Application no: H14-0099-11

Description: New flat roof to existing extension to include glazed lantern and new windows. Change hip roof to gable roof on single storey part of dwelling and fit gable window

Amendment: Amend roof to hipped pitched, remove gable from single-storey, lower eaves in two-storey, lower proposed windows

**PROPOSED WORKS AT LAUREL FARM HOUSE
YOUR REF H14-0099-11**

Proposed East elevation (revised)
Drawing number LFH5B Scale 1:100

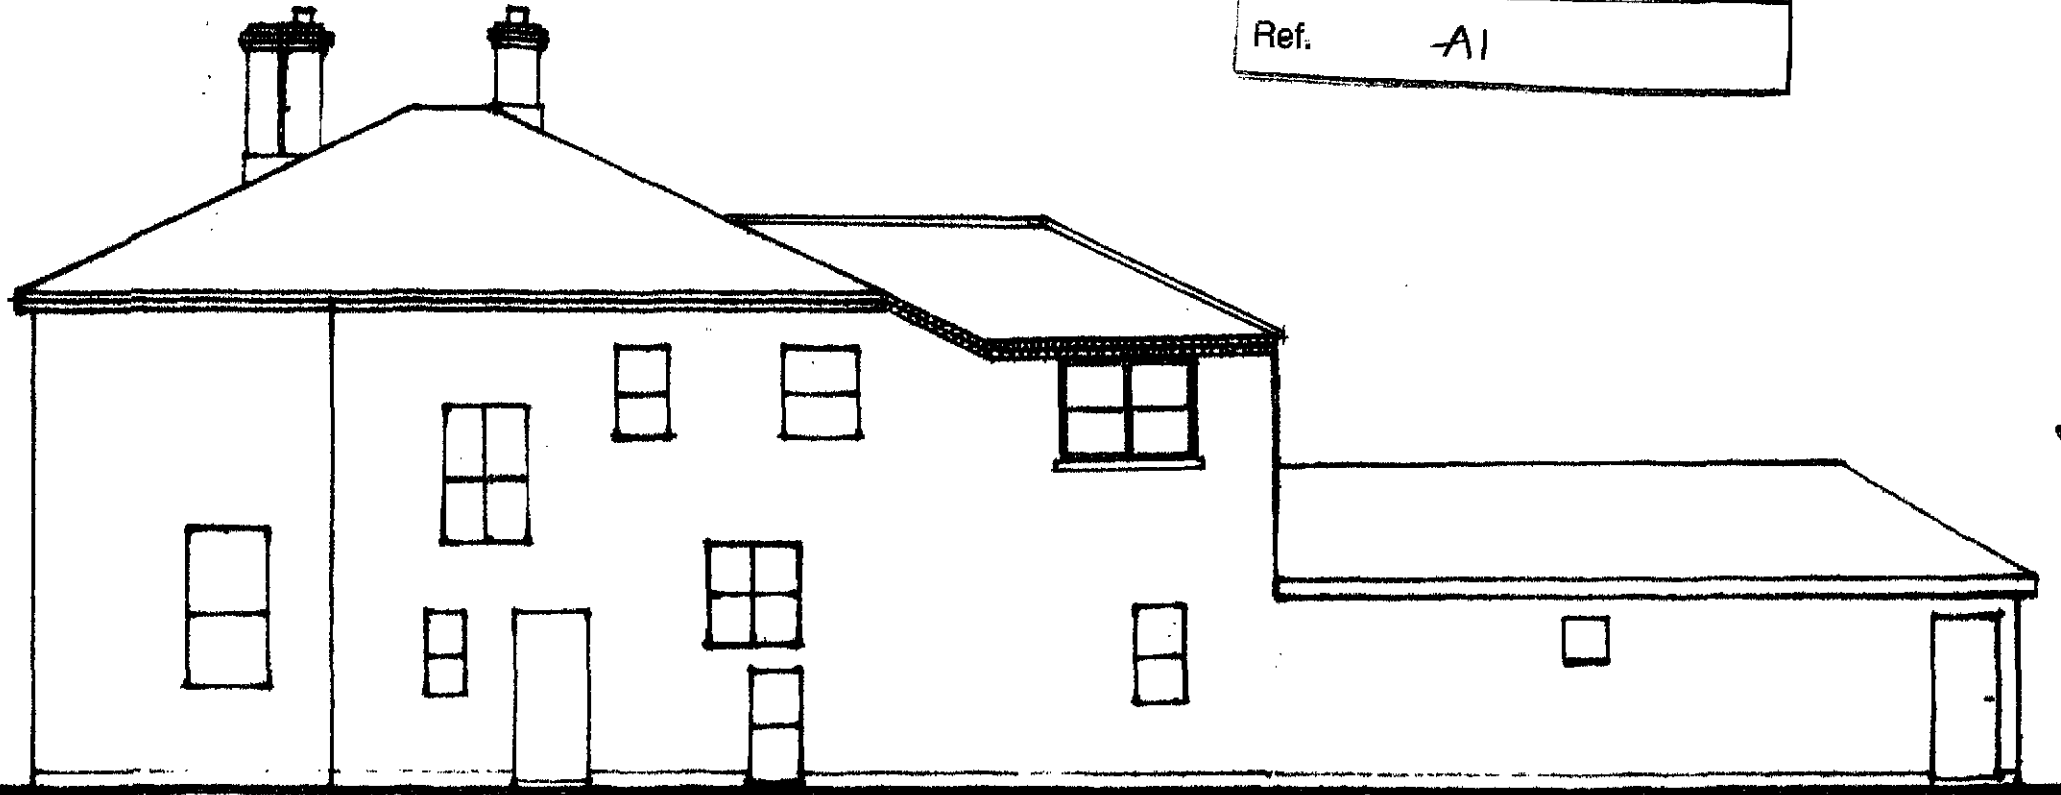
As you will see I have changed the roof of the proposed extension from a flat roof to a hipped pitched roof as you suggested, and I have removed the proposed gable from the existing single storey element. I have lowered the eaves of the two storey part in order to reduce the bulk and to retain the pyramid shape of the main house roof. The proposed windows have been lowered to suit and will be positioned directly below the corbelling brickwork which will be copied from the existing building.
